30 May 2011

**Re: M5 Widening Project – Non Inclusion of Noise Walls on M5 Liverpool Georges River Bridge**

Figure 8.7 Location of existing and proposed new or augmented noise walls

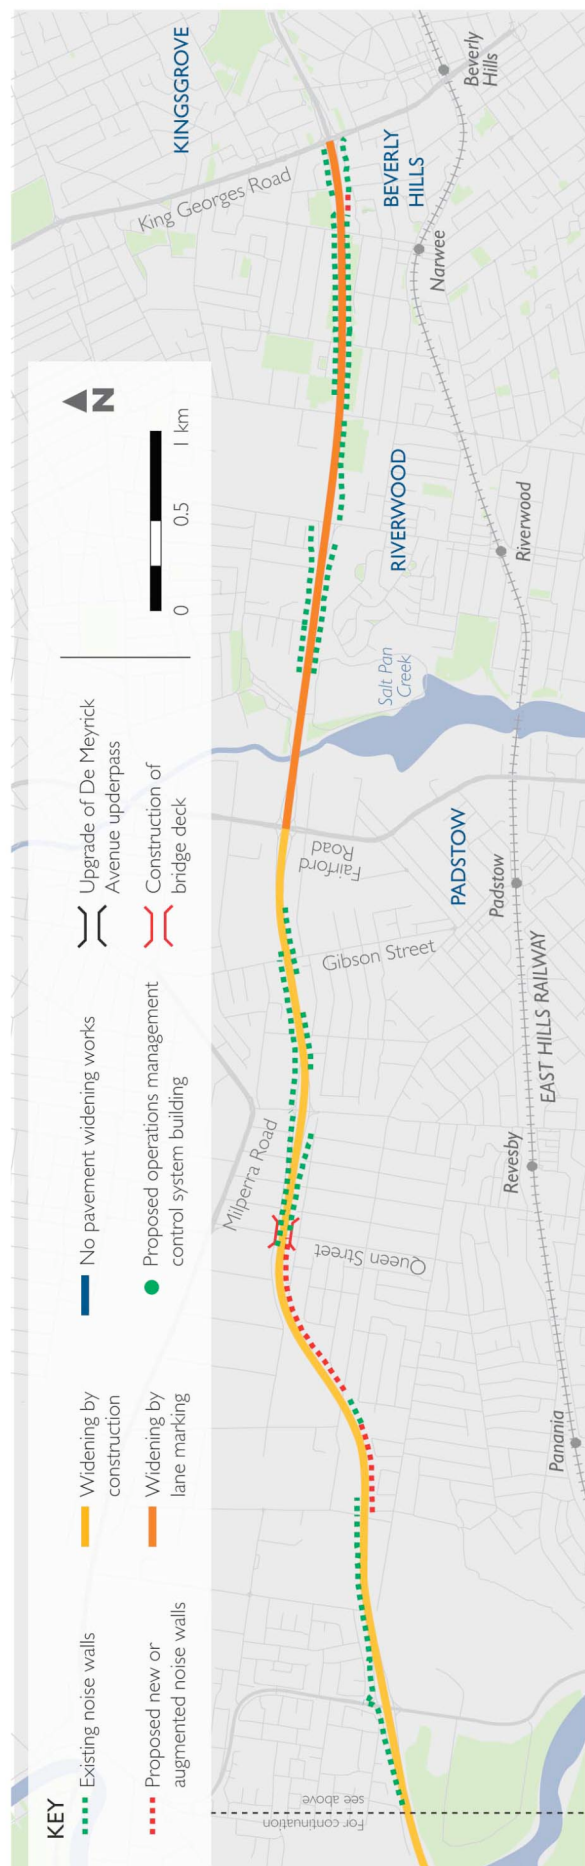
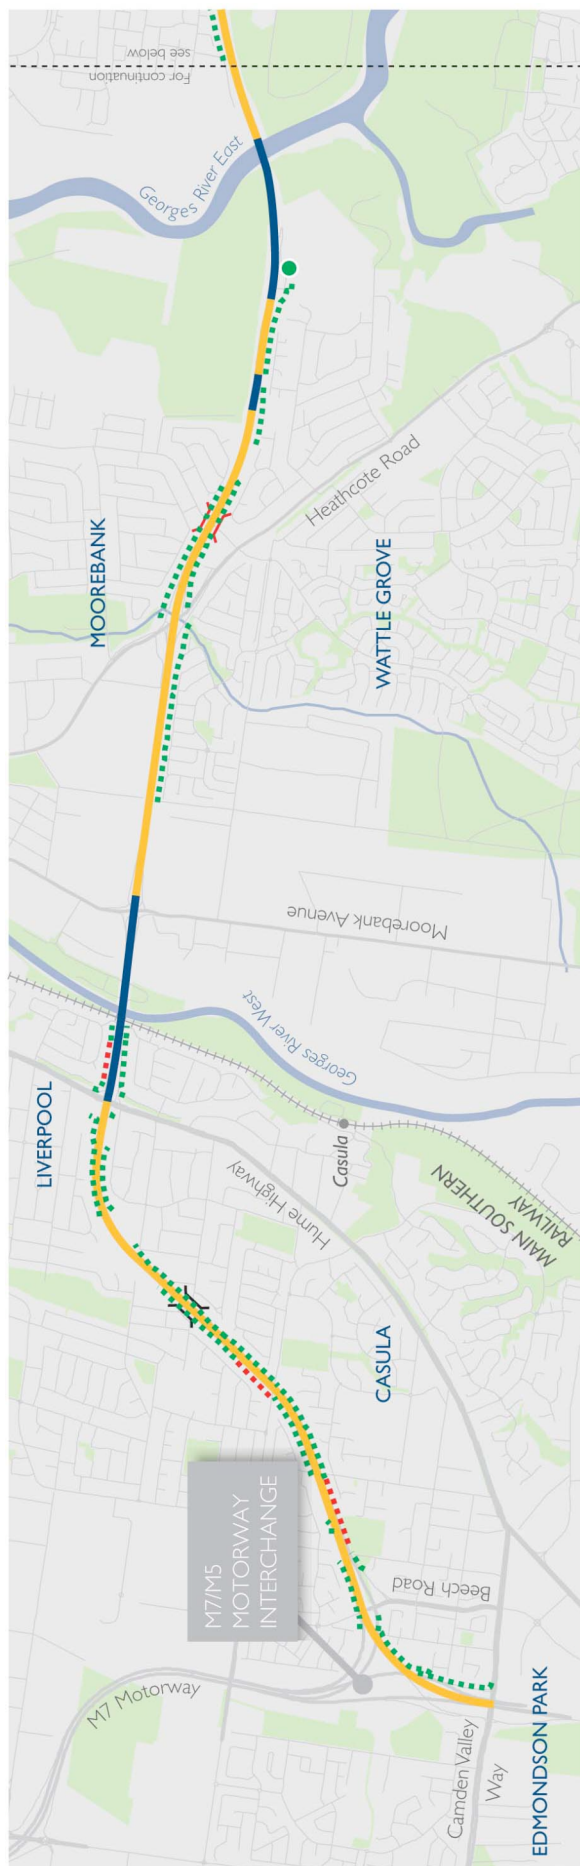
Further, the inclusion of appropriate noise walls on the M5 Liverpool Georges River Bridge would significantly reduce noise levels. M5 WW Volume 2 Appendix C - Section 8.7 indicates a noise reduction of 10dba could be achieved. Such a reduction would clearly place noise nearer to Environmental Criteria for Road Traffic Noise (EPA 1999).

We note that no noise barriers are proposed for the M5 Georges River Bridges at Casula.

Noise barriers on the bridges are essential.
